Planning - Case Comments

Project Number: PR-2024-011242

Application Number: SI-2025-00079

Project Name: 1401 Innovation Parkway SE- PNM (ESS)

LIGHTING PLAN

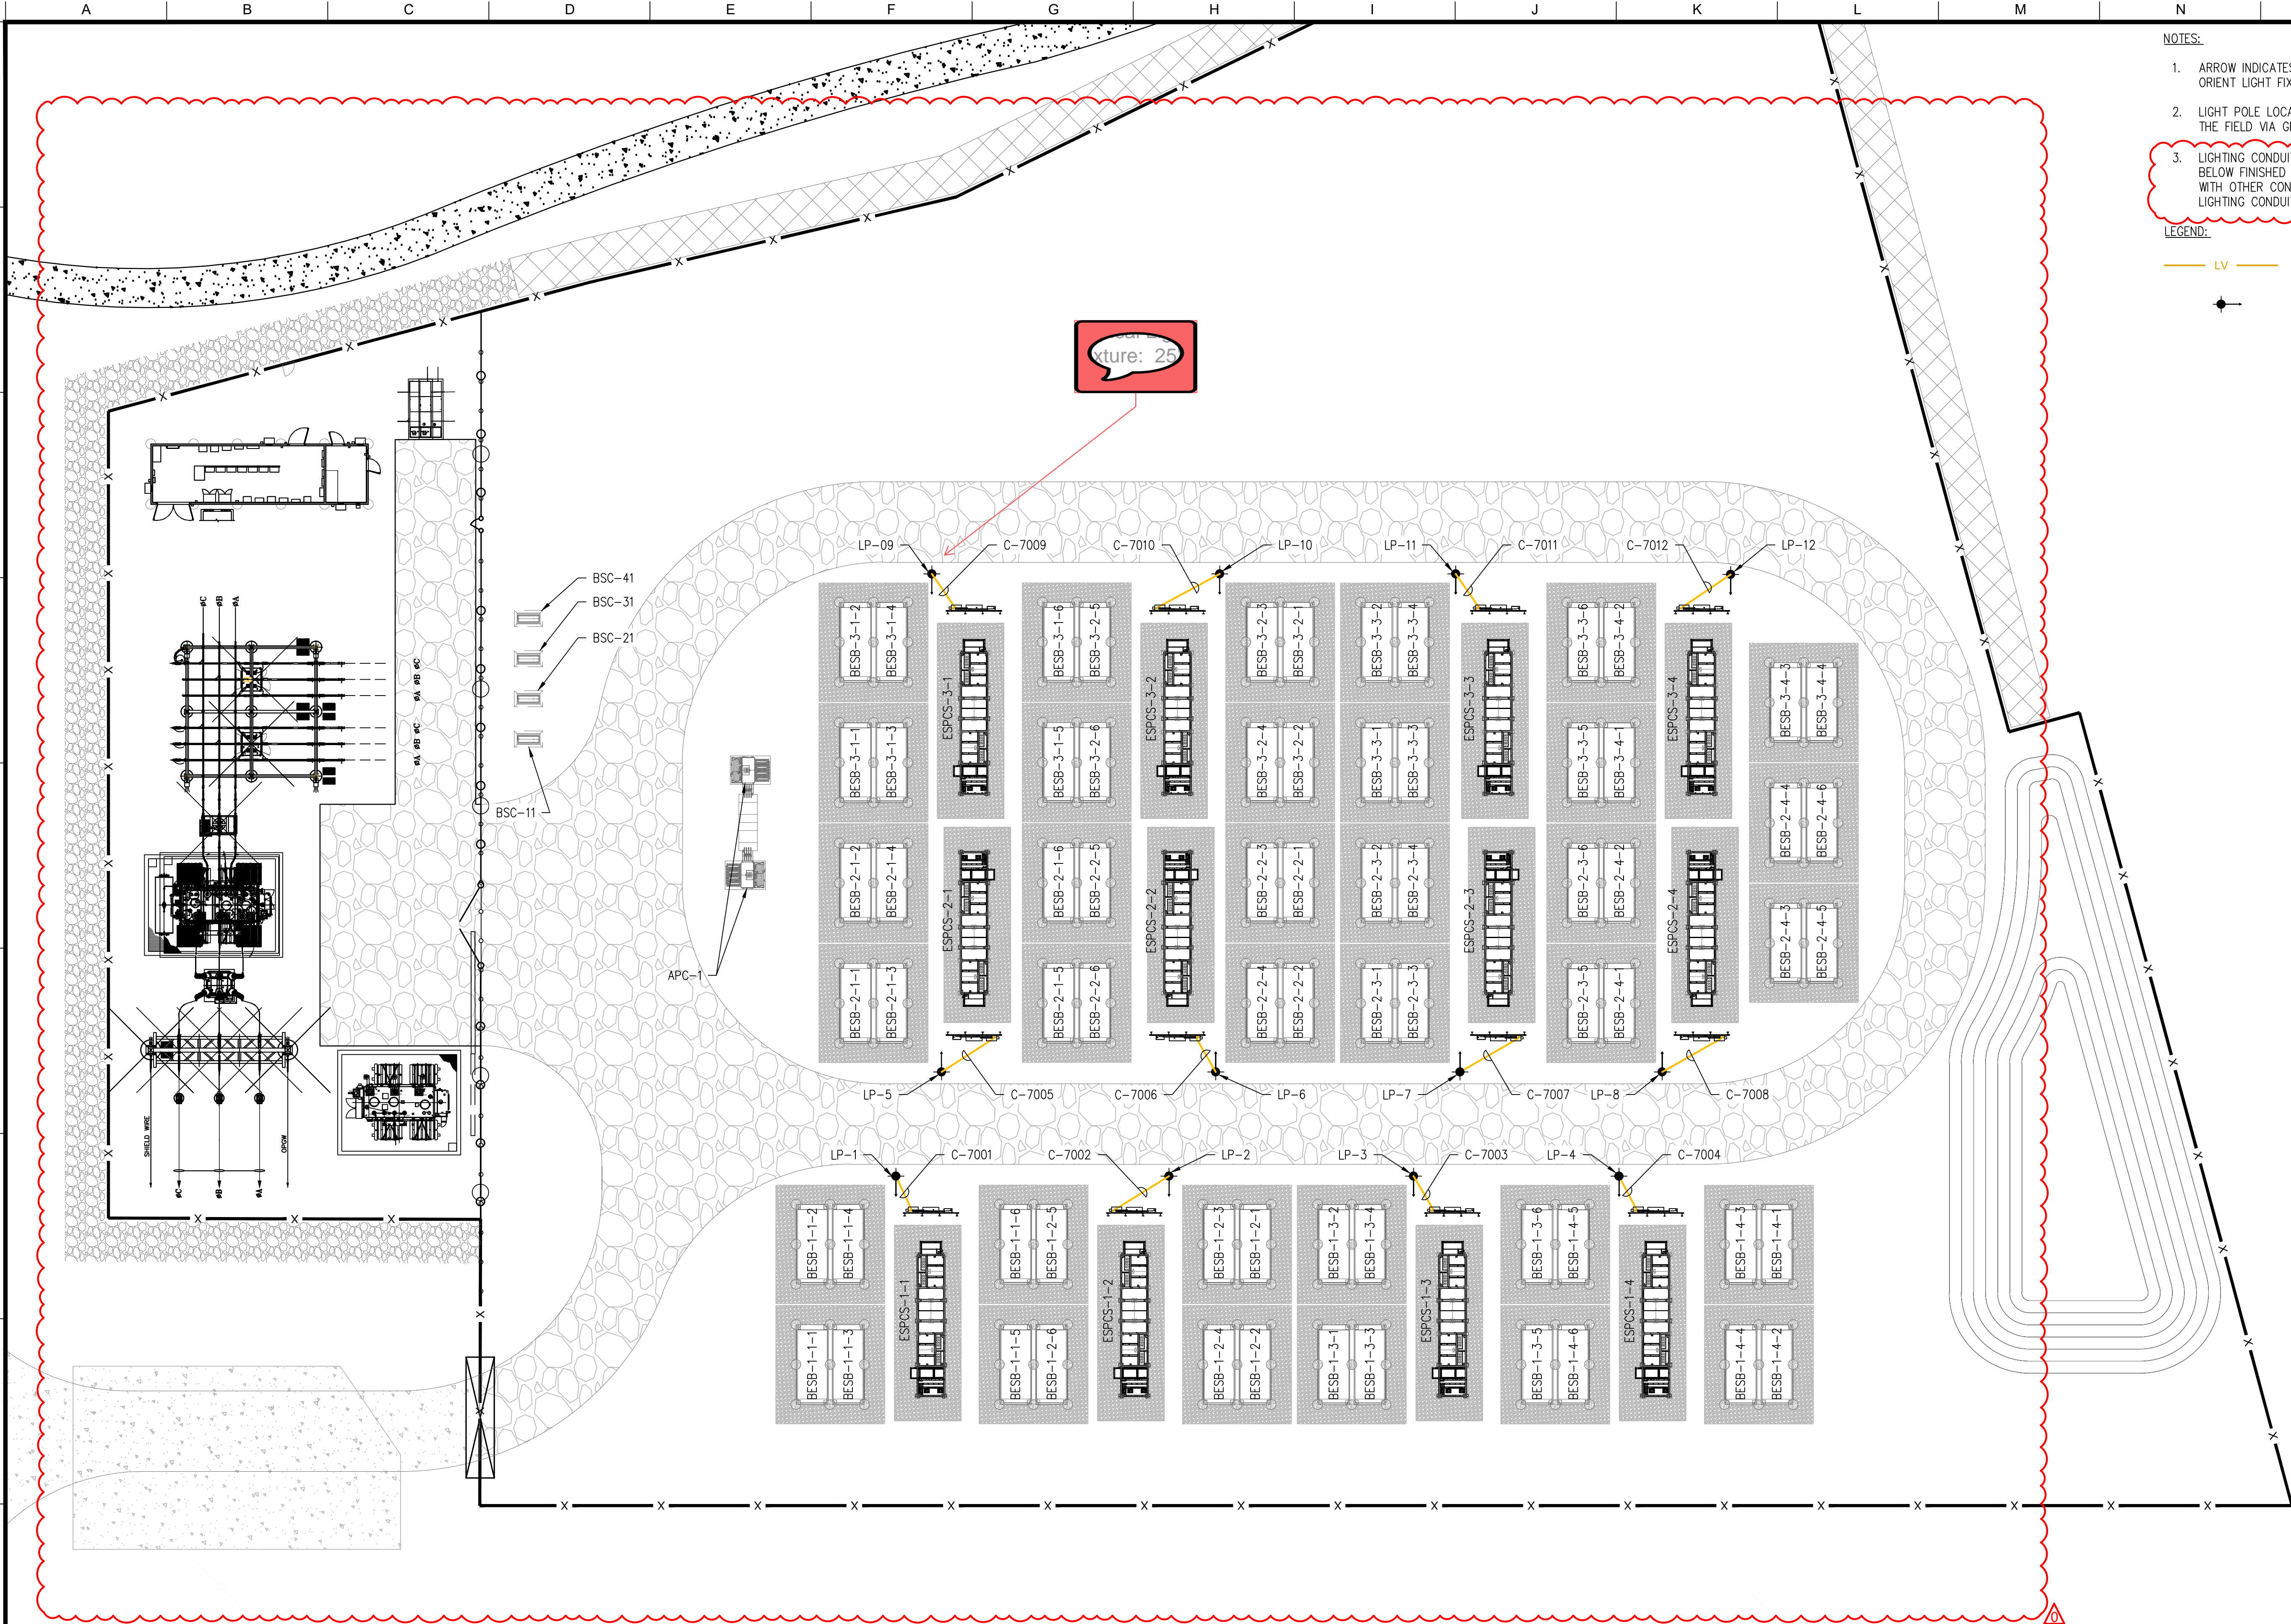
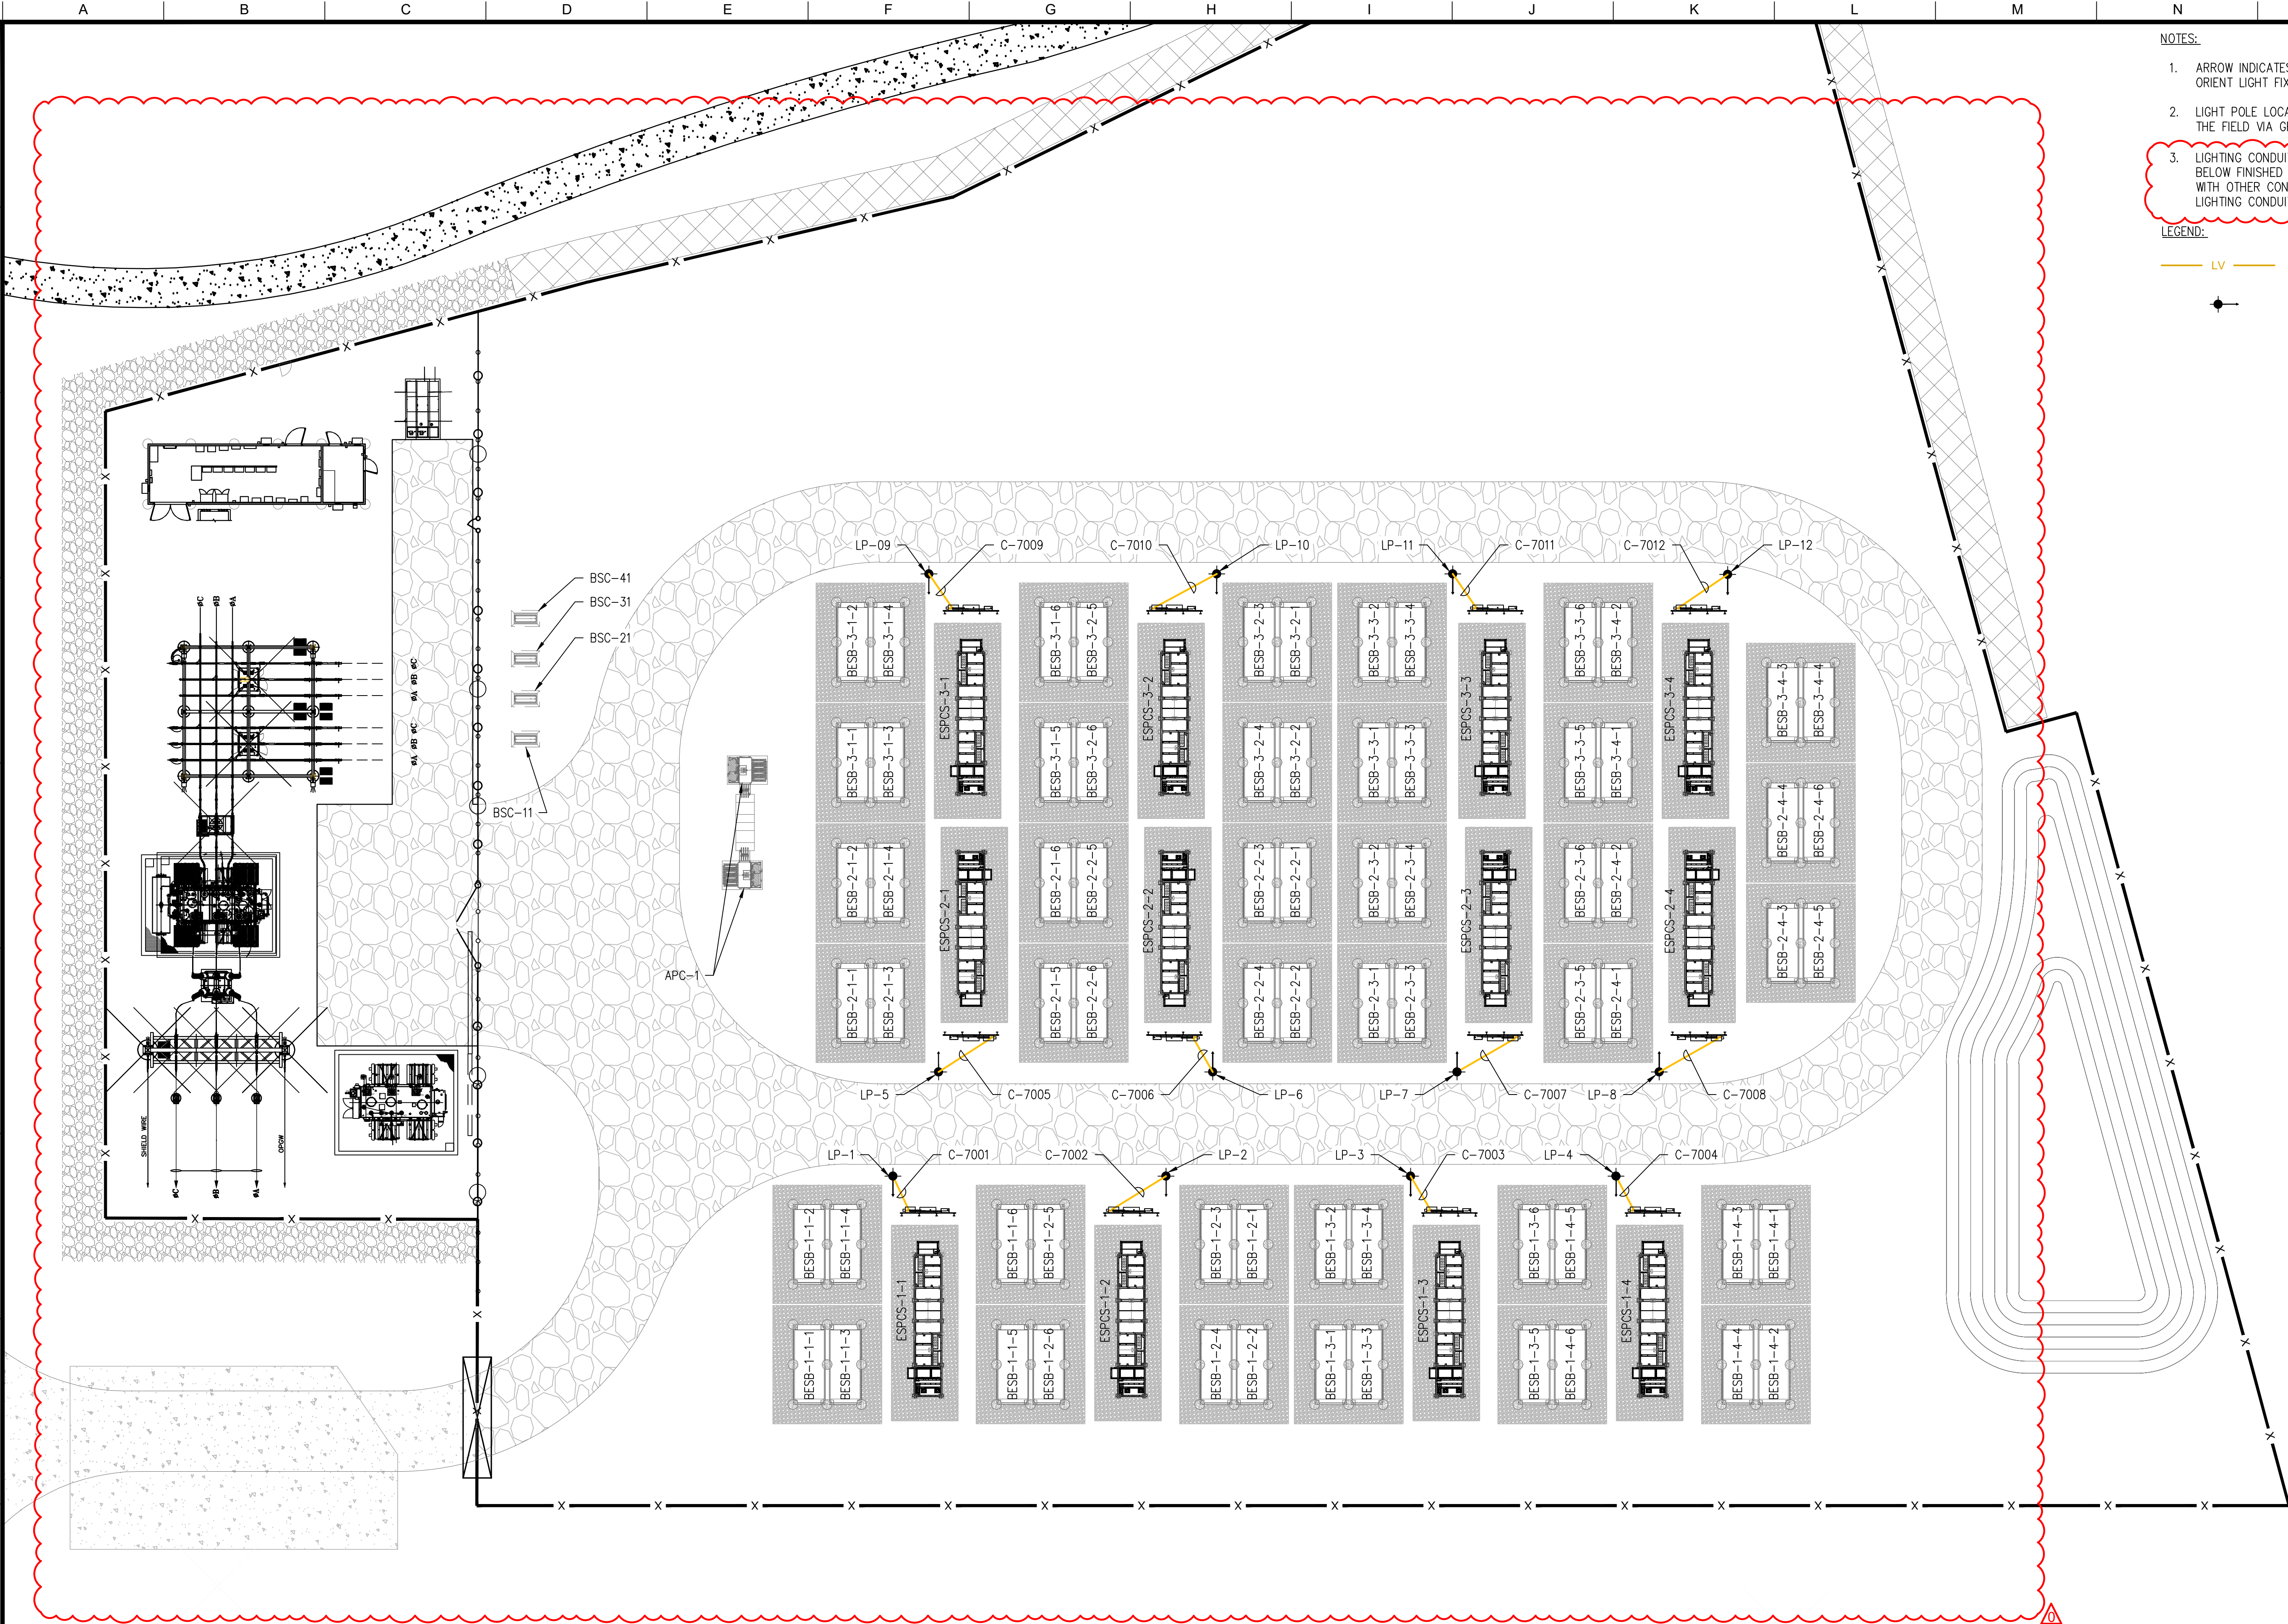
- All lighting is designed to be Night Sky compliant and consistent with Section 14-16-5-8. Please confirm compliance with 5-8 Outdoor and Site Lighting.
 - **PNM RESPONSE: PNM has reviewed section 14-16-5-8 and modified our**

lighting plans to ensure we are compliant with the lighting requirements. The light poles have been reduced to 25' and glare shields are now included. Additionally, the light output, light schedules, etc. is programable and controllable. The lights are tied into the security system and will be in a wide cast low-lumen glow at night. This output is similar to lighting of a parking garage at night. However, if motion, heat signature, or radar detects movement the light output will significantly increase in the vicinity to aid in signature capture. It should be noted that the light is designed to be captured within the perimeter of the Wall. To get a visual of this see the models on page 3 of the updated "Light Fixtures and Lighting Plan."
